Subject: Natural England's comments on the HRA for applications P/93/21/PL (Arun DC) and 21/01921/FULEIA (Chichester DC)

Further to our meeting earlier with Nick Gibb MP, please see below summary of the items required by Natural England.

Drawing B

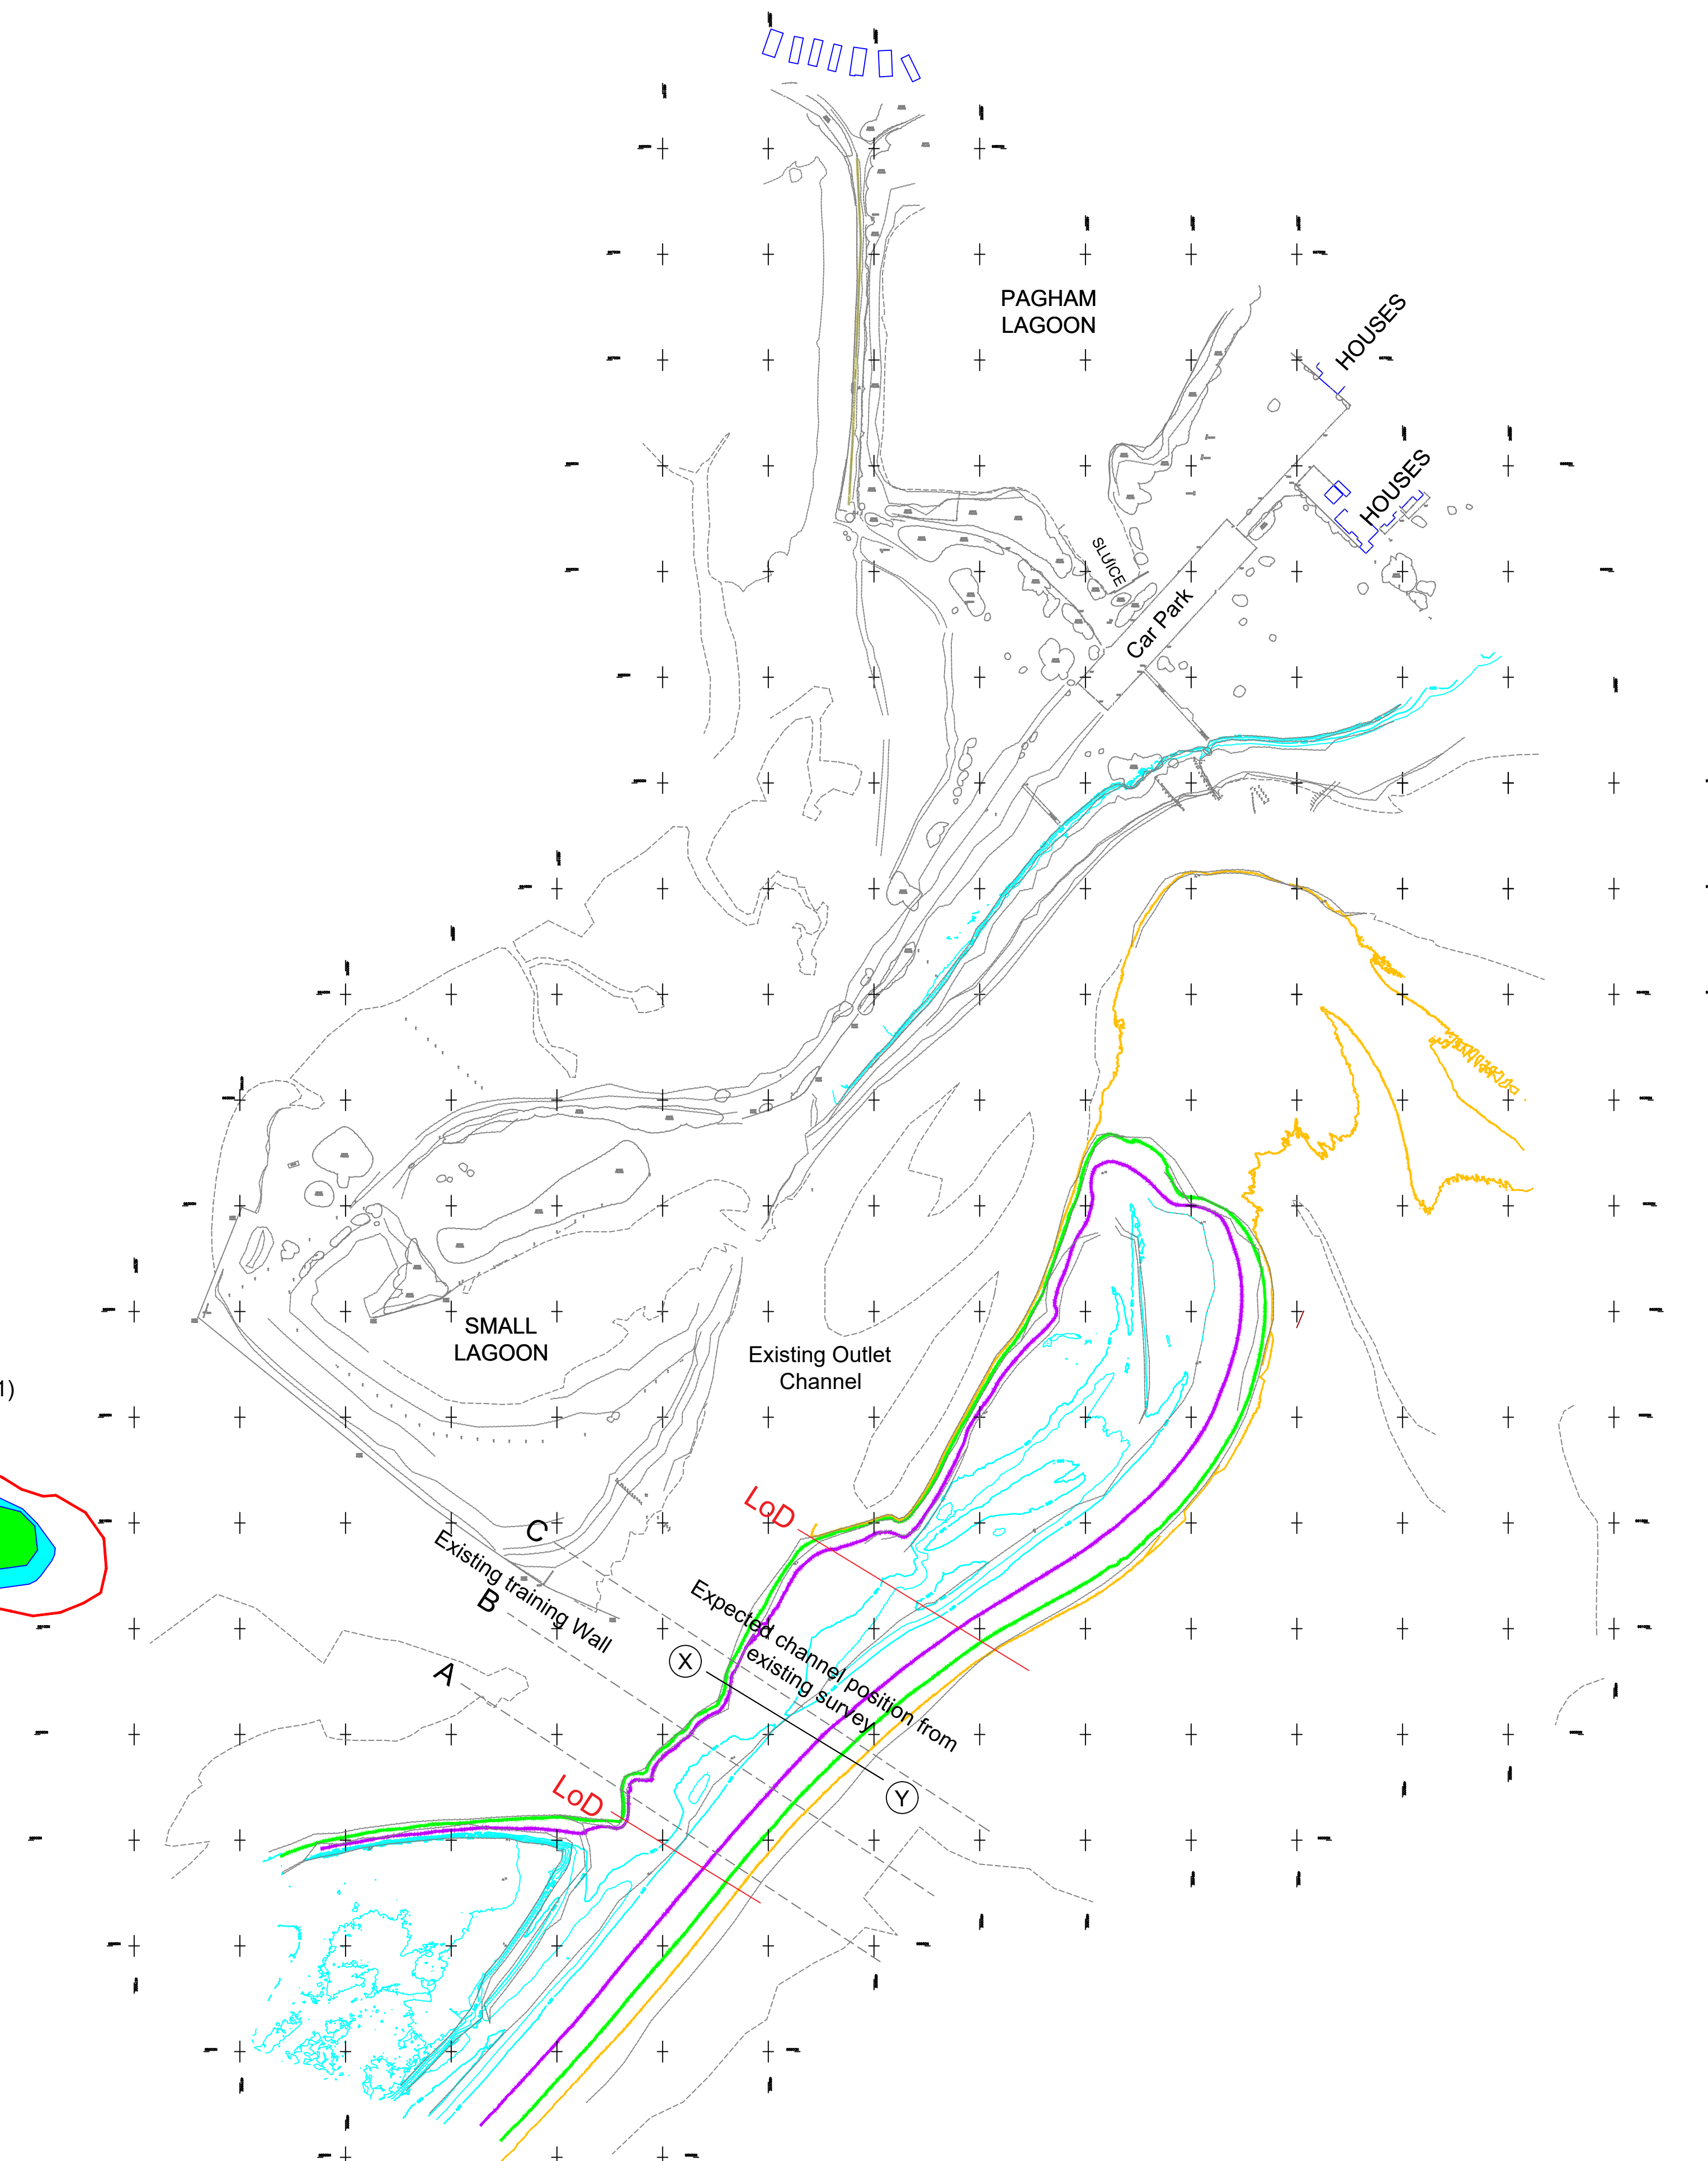
- (3) The size of the compensation island - is it designed to maintain the population at the current 46 pairs? (page 19)
